Your Ref: OWPC17768
Our Ref: FG/202/17/PL 15-12-2017
Please ask for:
Ross Leal

Change of use from restaurant (A3 Restaurant) to takeaway (A5 Hot Food Takeaway),
repositioning of extraction flue, removal of existing rear extensions, erection of rear
extension for 1 No. flat.

104 Ferring Street Ferring

Proposed Roof Plan

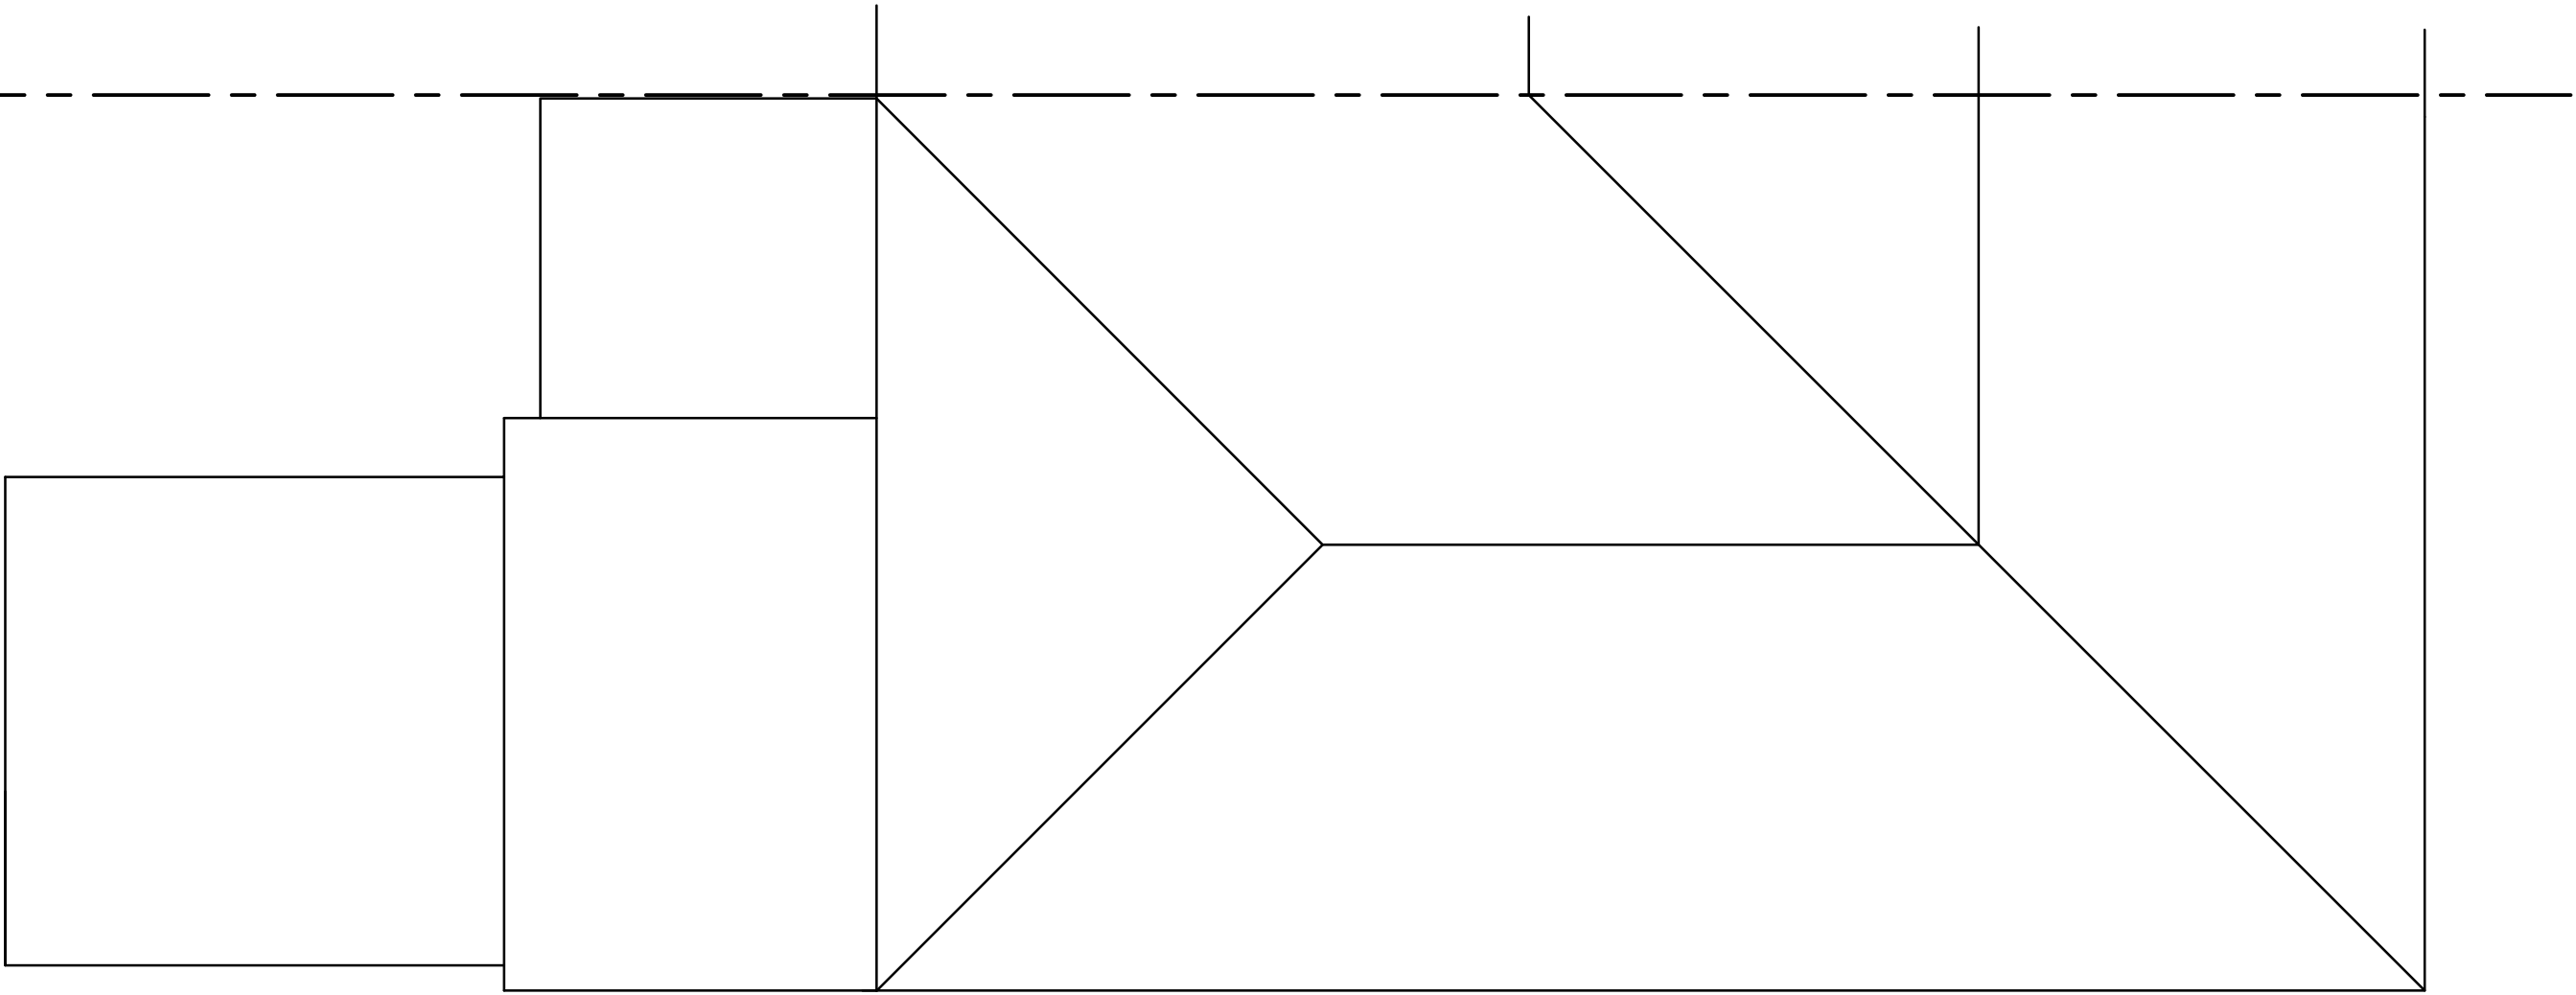
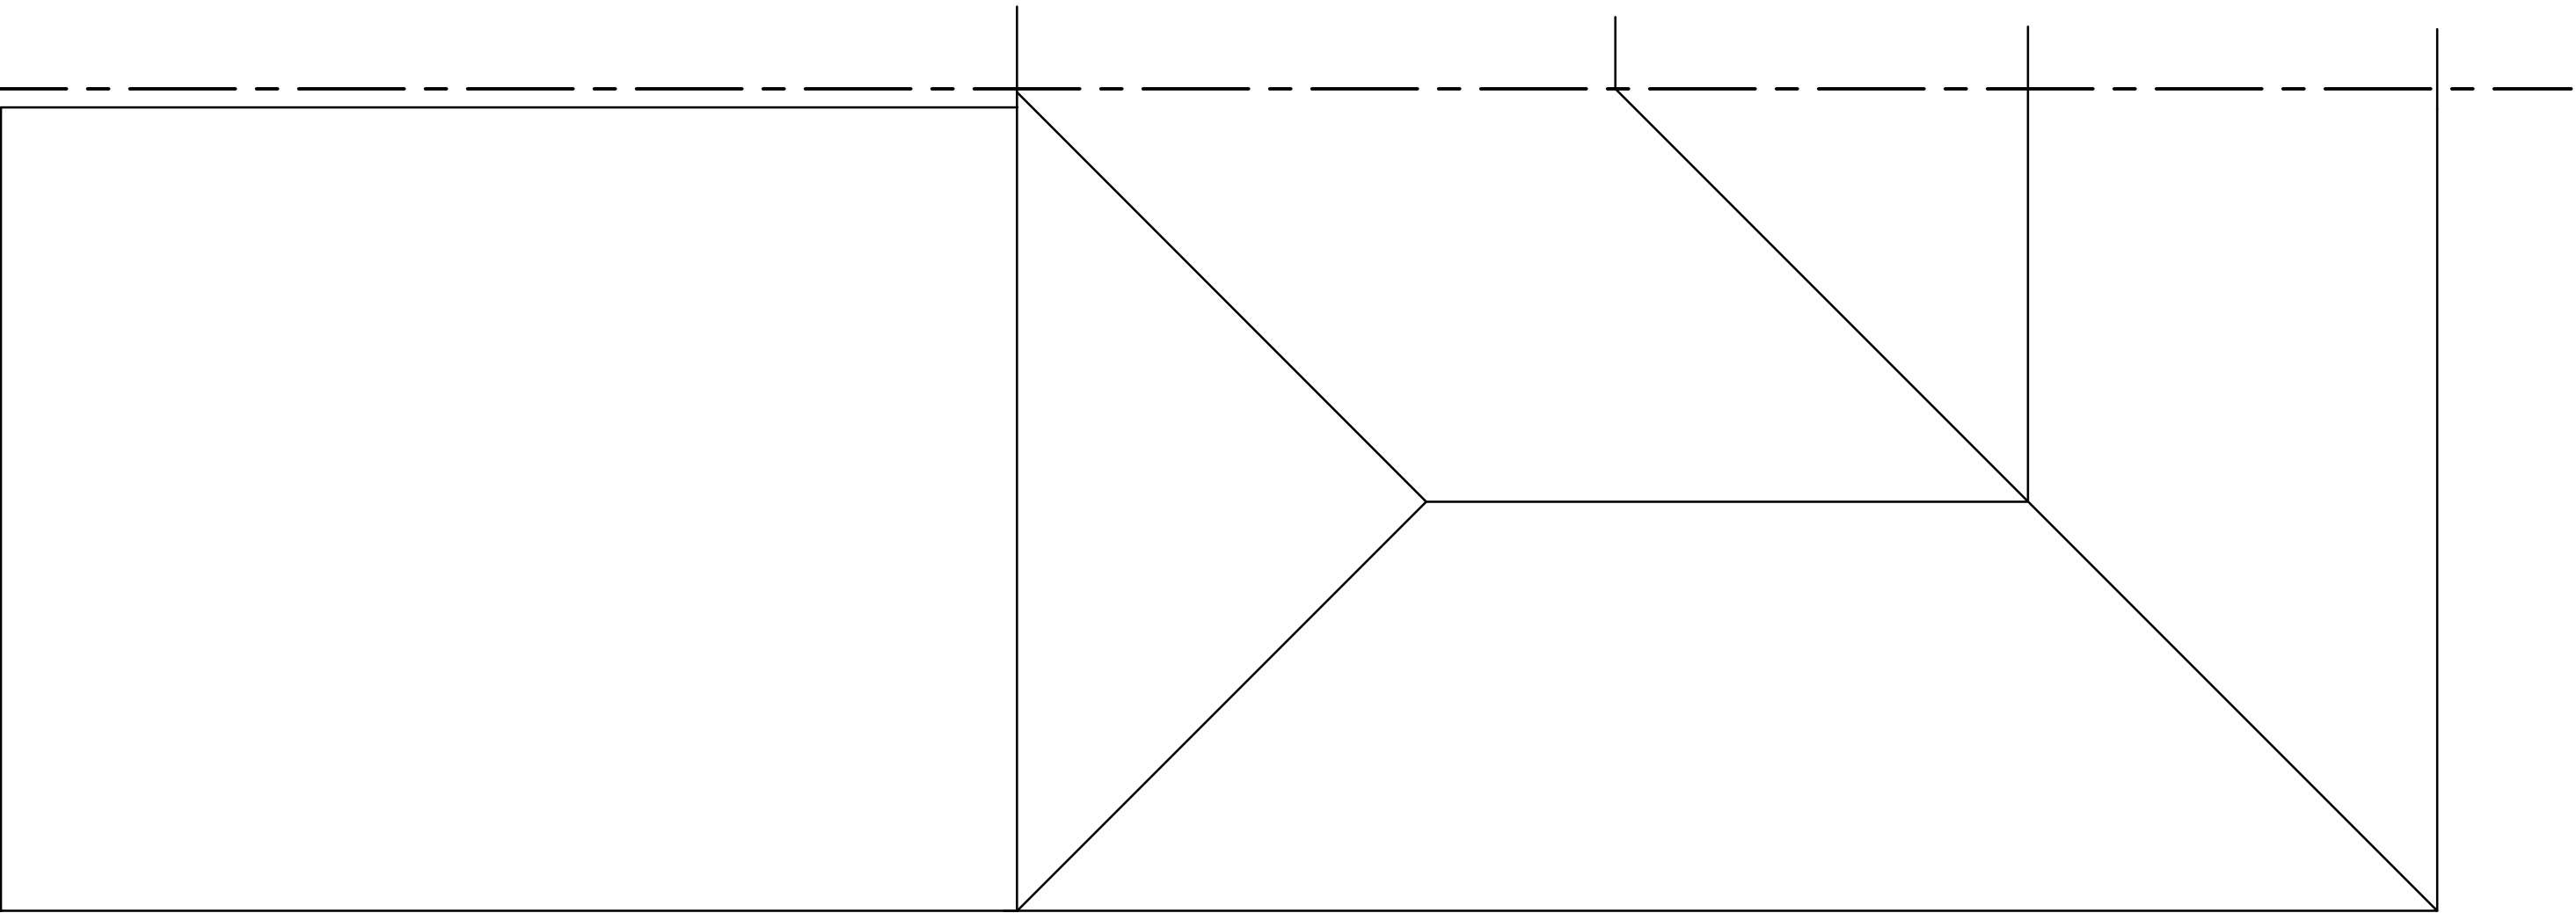
*MY ONLY CONCERN IS THE DIAMETER OF THE PROPOSED NEW EXTRACTION
FLU. THE ORIGINAL FLUE SIZE IS NOT TRUE TO SCALE AND LOCATION ON THE
APPLICATIO*
